The Able Marine Energy Park (Amendment) Order 202[]

An application has been made to the Secretary of State under paragraph 3 of Schedule 6 to the Planning Act 2008(a) in accordance with the Infrastructure Planning (Changes to, and Revocation of, Development Consent Orders) Regulations 2011(b) for a material change to The Able Marine Energy Park Development Consent Order 2014(c).

This Order follows an application under paragraph 3 of Schedule 6 to the Act for a material change to the 2014 Order to allow—

**Works Plan - Key Plan**

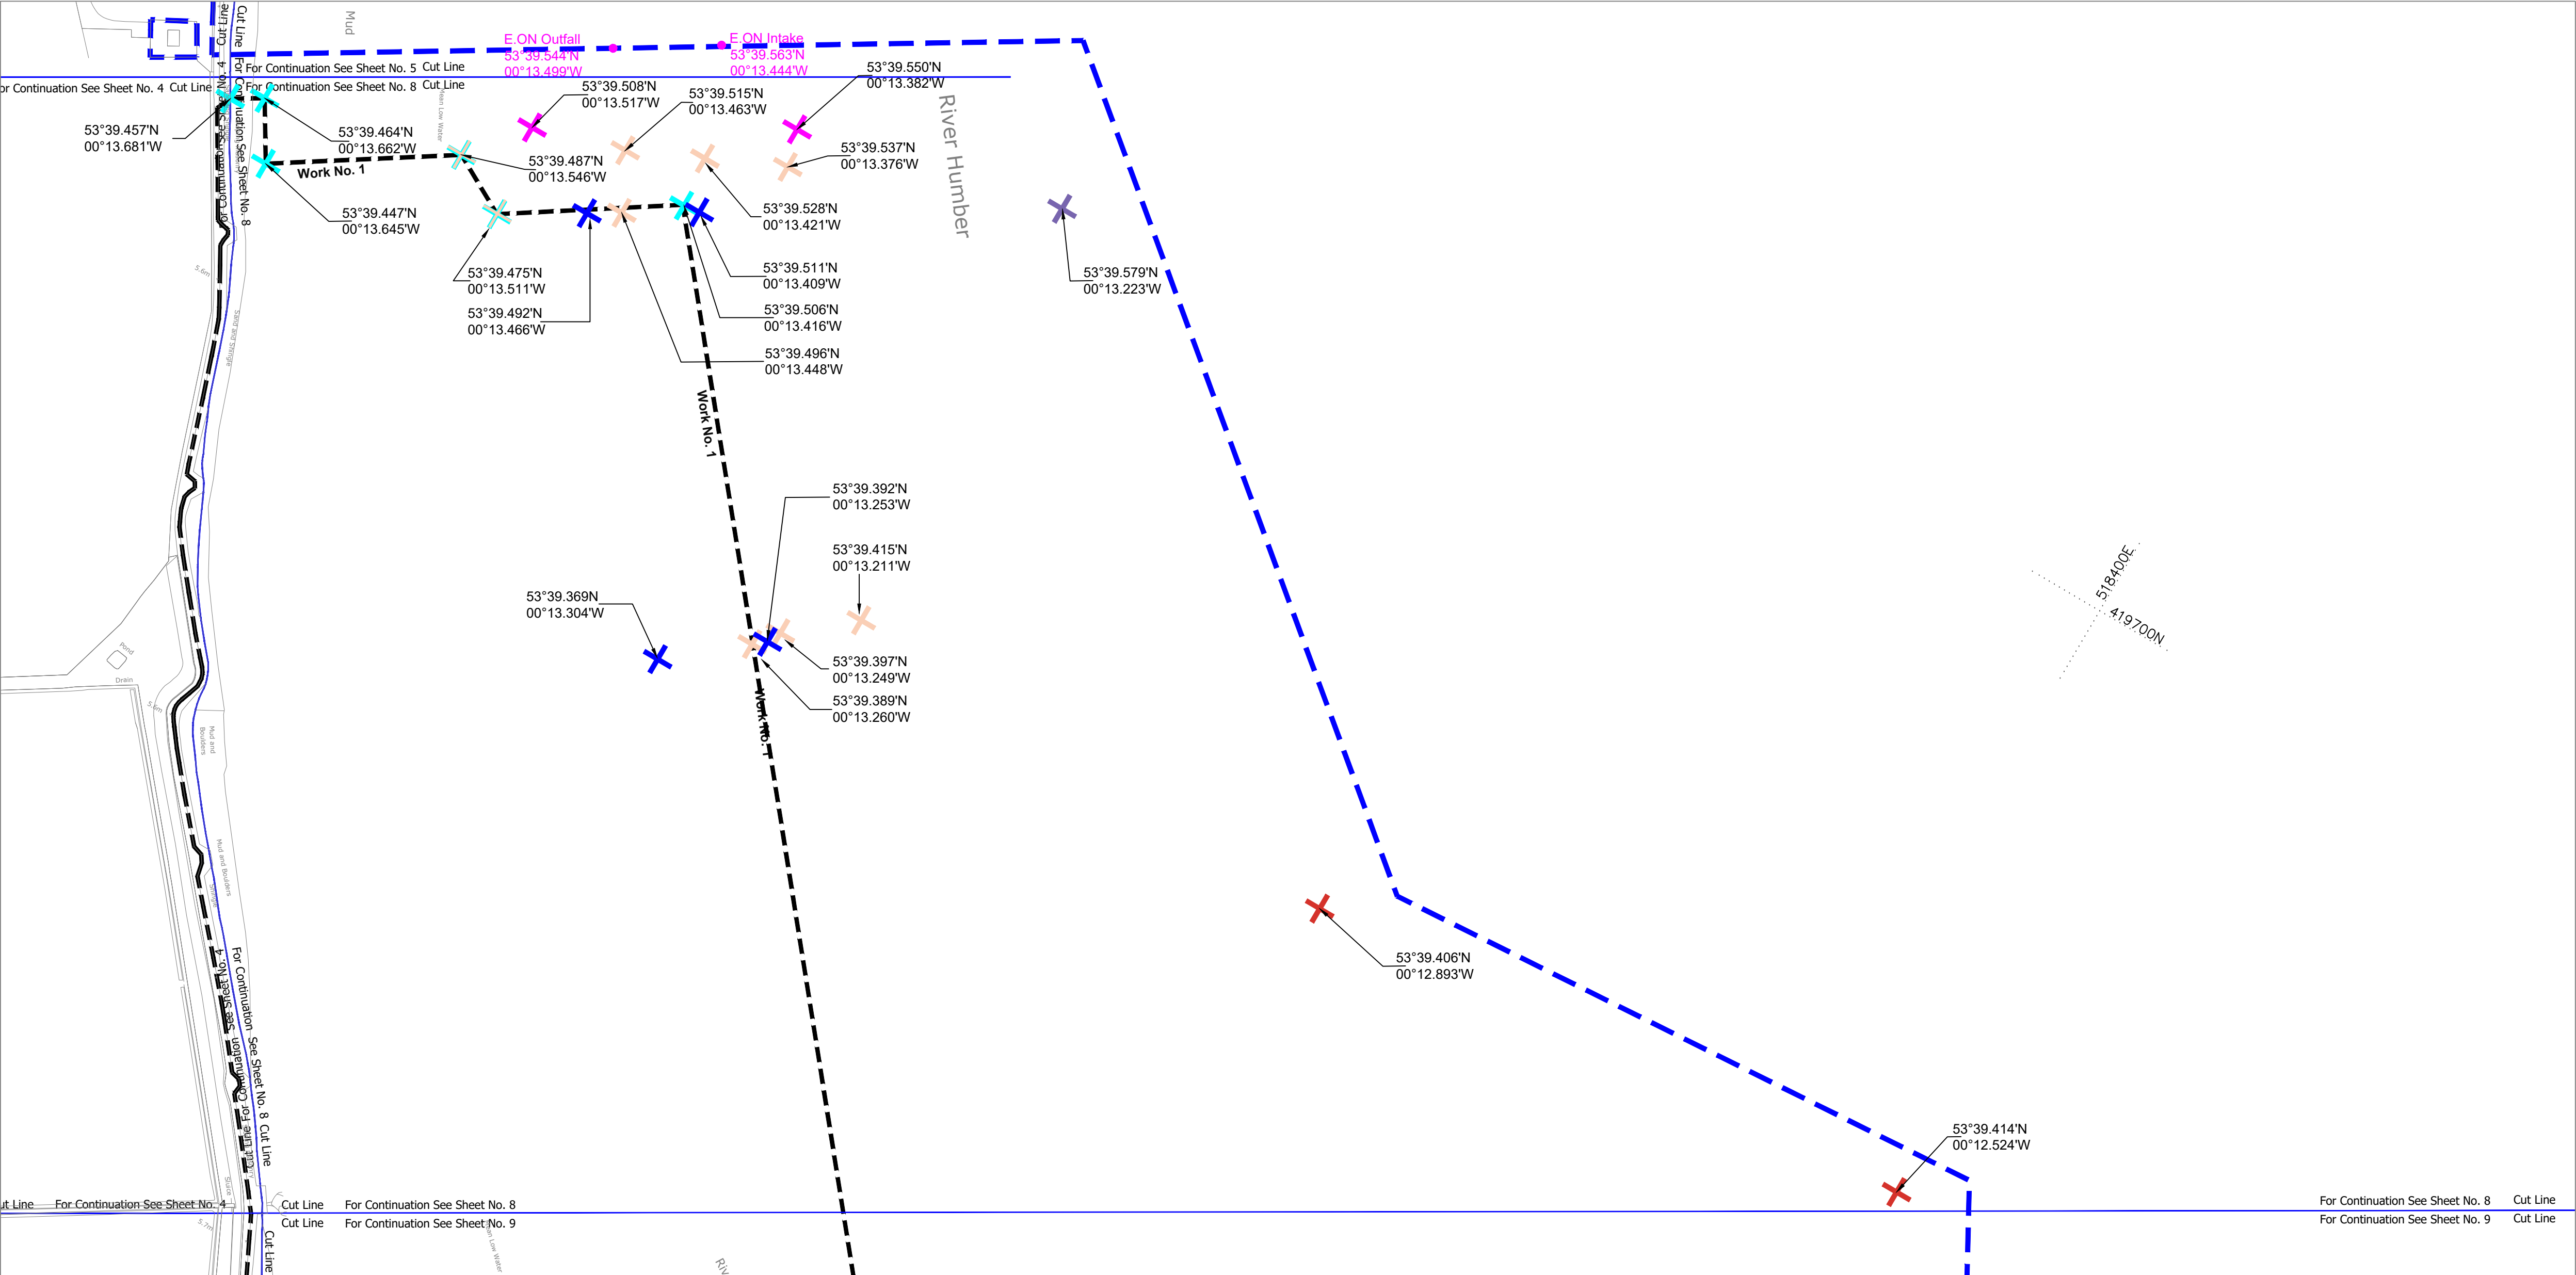
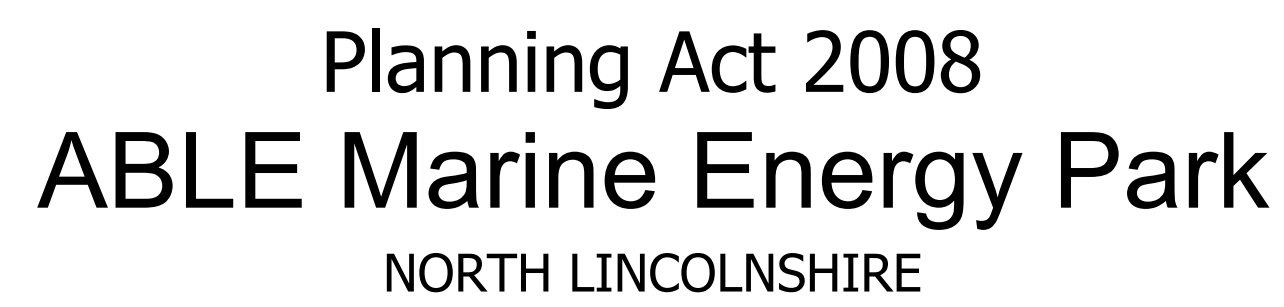
“the inset berth” means the area bounded by co-ordinates (53°39.492'N, 00°13.466'W), (53°39.511'N, 00°13.409'W), (53°39.392'N, 00°13.253'W) and (53°39.369'N, 00°13.304'W) and shown on sheets 8 and 9 of the works plans;”.

- (a) a realignment of the proposed quay (within its existing limits of deviation) to remove a berth pocket at the southern end and introduce a setback at the northern end;
- (b) changes to the construction methodology to allow the relieving slab at the rear of the quay to be piled at the surface or to be omitted, the use of anchor piles instead of flap anchors, and to permit alternative options as regards the number of cross dams to be used and the sequencing of the quay works;
- (c) consequential changes to dredging; and
- (d) unrelated to the quay changes, the realignment of a footpath diversion to the north west of the site to go round the end of a railway track instead of crossing it.
